**Our Ref: FP/10/13/
Your Ref:**

**Town & Country Planning Act 1990 (as amended)
Town and Country Planning (Development Management Procedure) (England) Order 2010 (as amended)
Application for Planning Permission**

Development Change the use of former builders yard (sui generis) to private garden (sui generis) with fence
Location Land adjacent to 3 Shirleys Garden Felpham

Site and Block plan

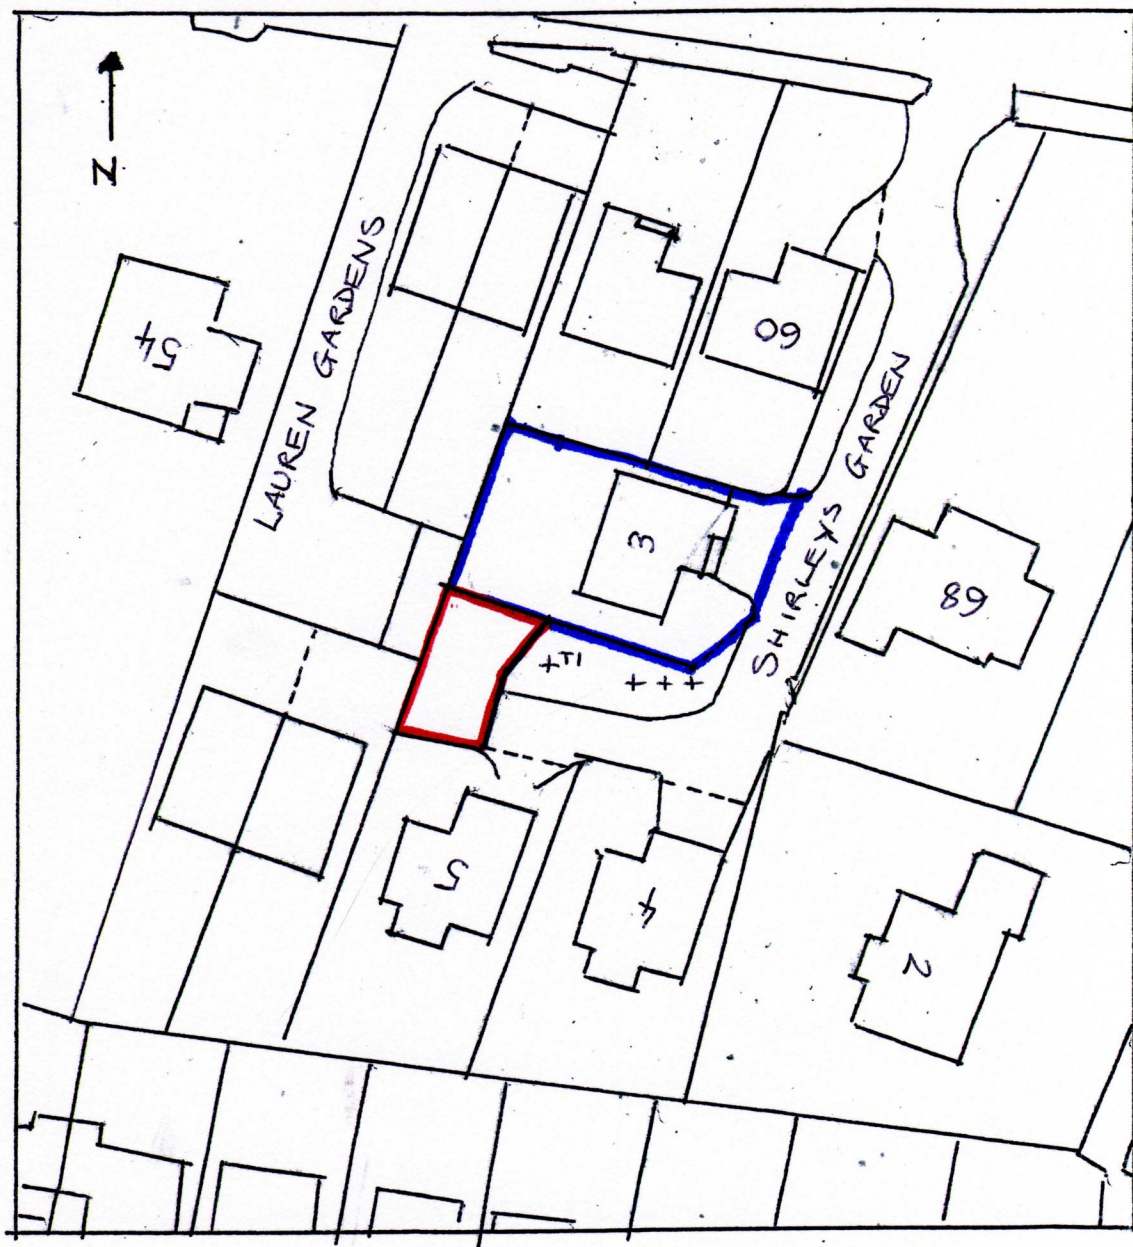
The Block plan and the plan, showing the details of the fence size, do not scale properly. Please provide a scale for the plan showing the details of the fence.

SITE PLAN AND ELEVATIONS

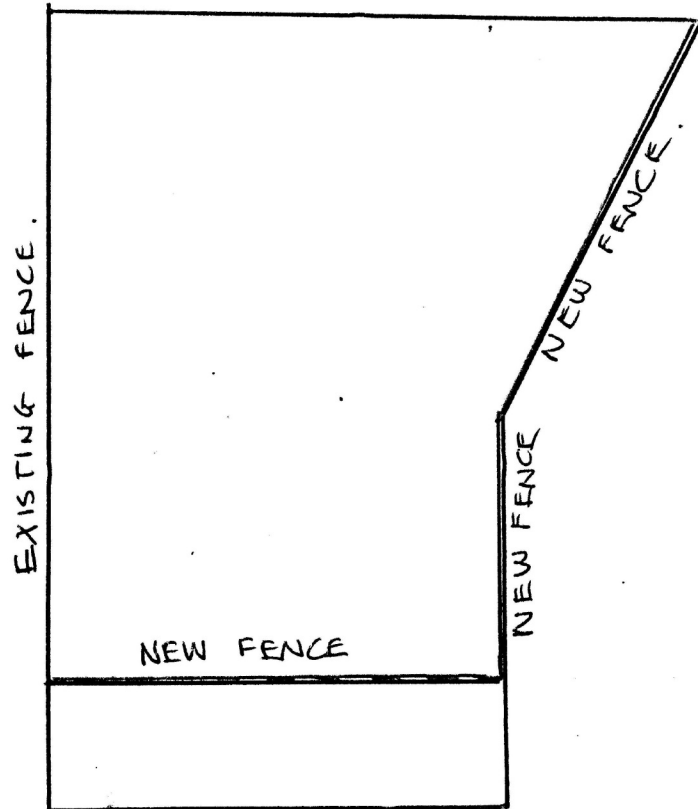
Please provide elevations and details of the new fence.
